**PROPOSED COMMERCIAL WORKSPACE AND OFFICE DEVELOPMENT  
ST MARYS STREET, PENISTONE, S36 6DT  
APPLICATION REFERENCE: 2011/0106**

Please find enclosed revised plans in relation to the elevation details for the above application currently under determination with yourself.

The revisions are not significant and the main changes are the window design and layout, and the addition of a glazed lantern.

Rev A 24.01.11 - Material Notes Added
Rev B 16.02.11 - Window arrangement altered

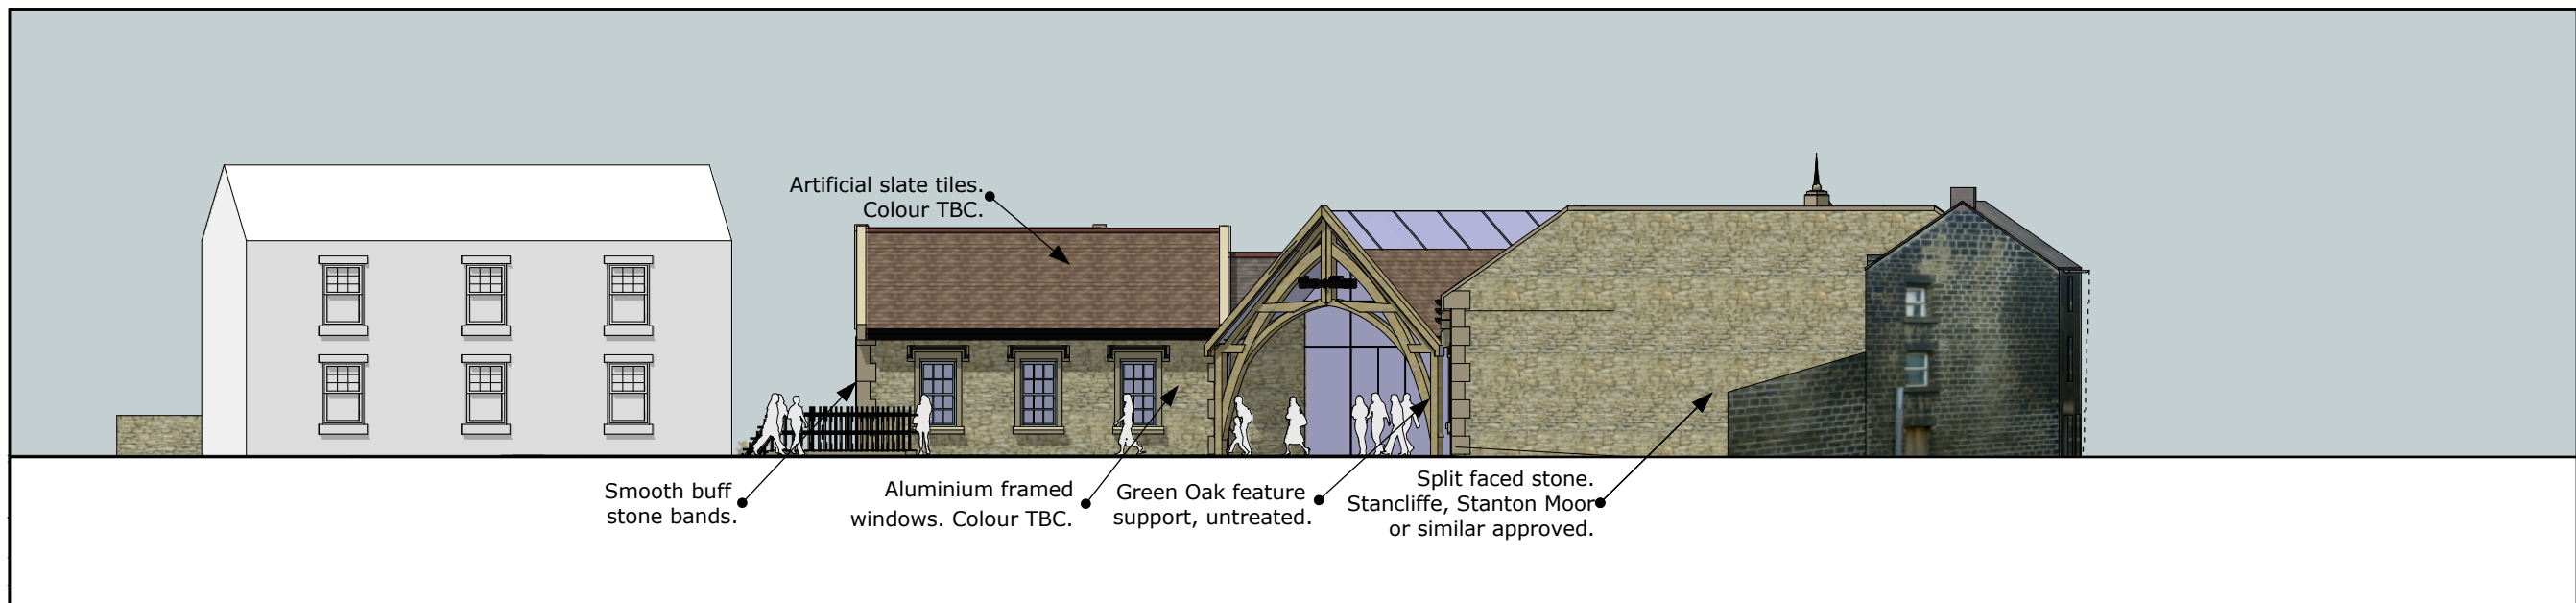
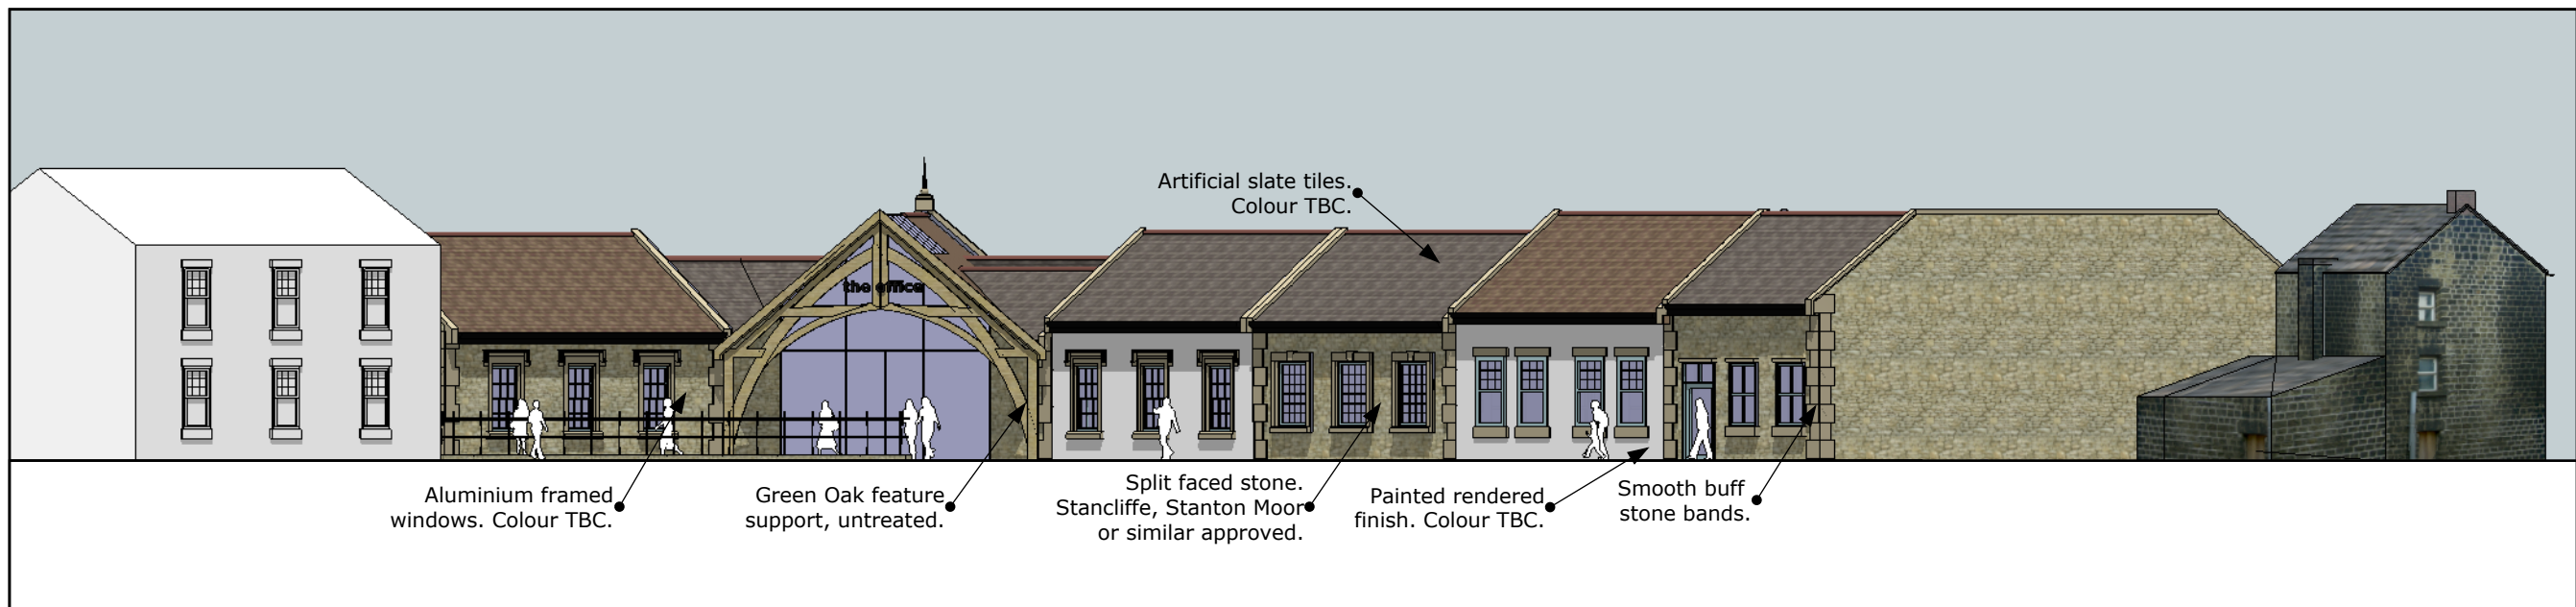
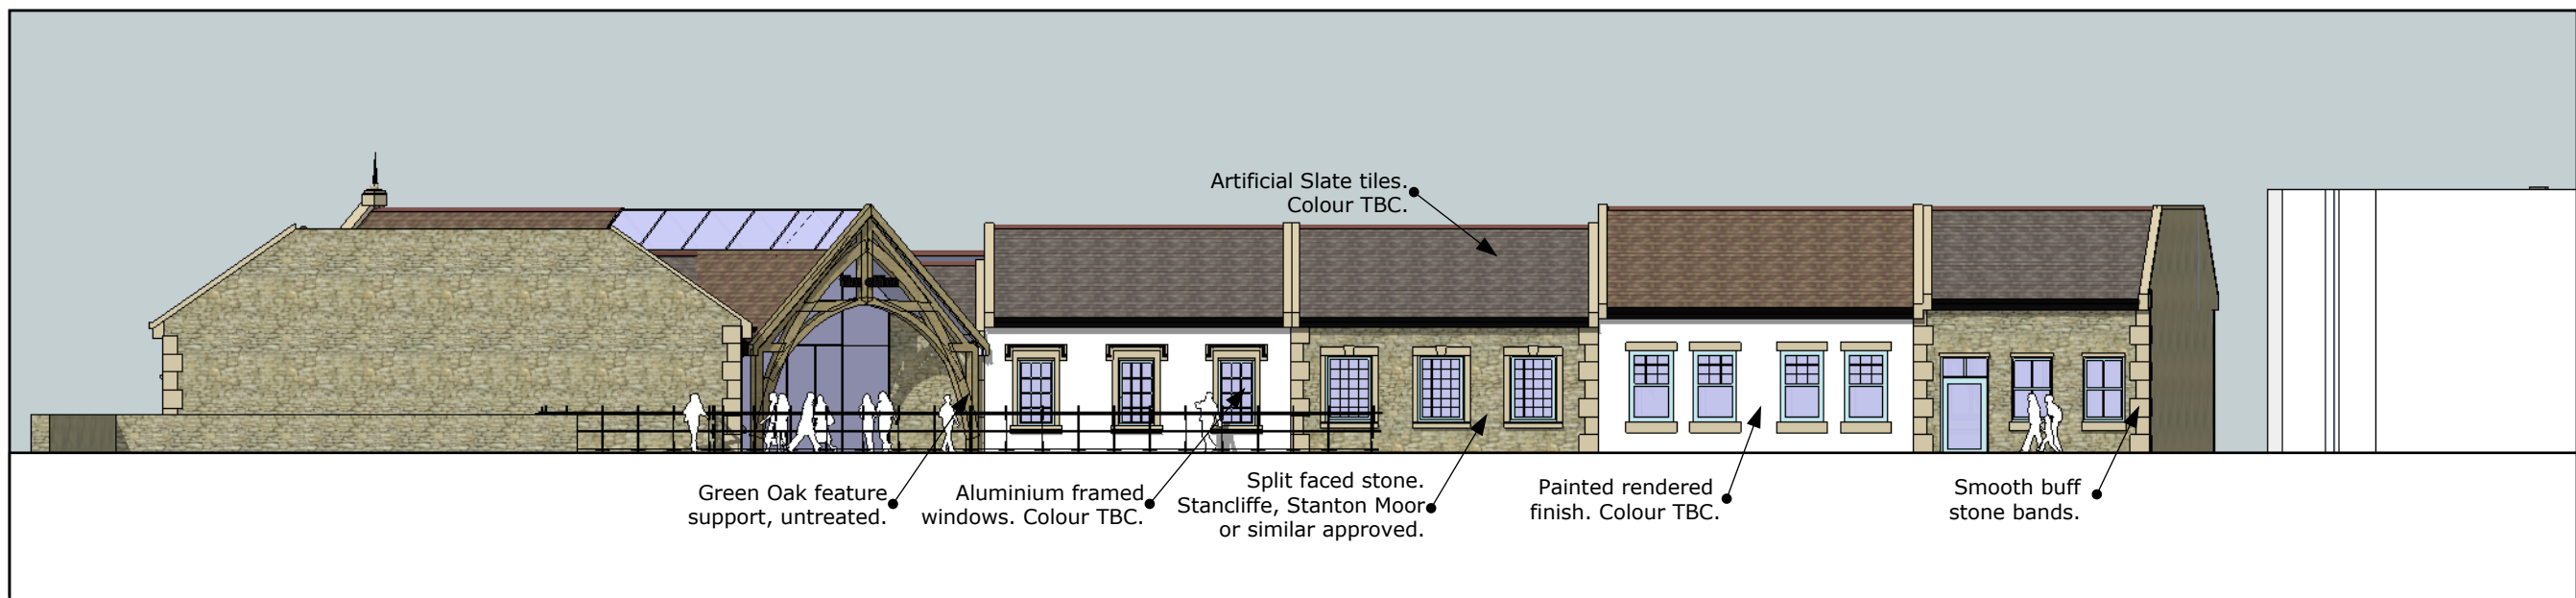
- **Original PL-06A** Proposed Elevations Sheet 1, to be **Replaced with PL-06B** Proposed Elevations Sheet 1
- **Original PL-07A** Proposed Elevations Sheet 1, to be **Replaced with PL-07B** Proposed Elevations Sheet 2
- **Original PL-08** Proposed Views, to be **Replaced with PL-08A** Proposed Views
- **Original PL-09** Proposed Views, to be **Replaced with PL-09A** Proposed Views
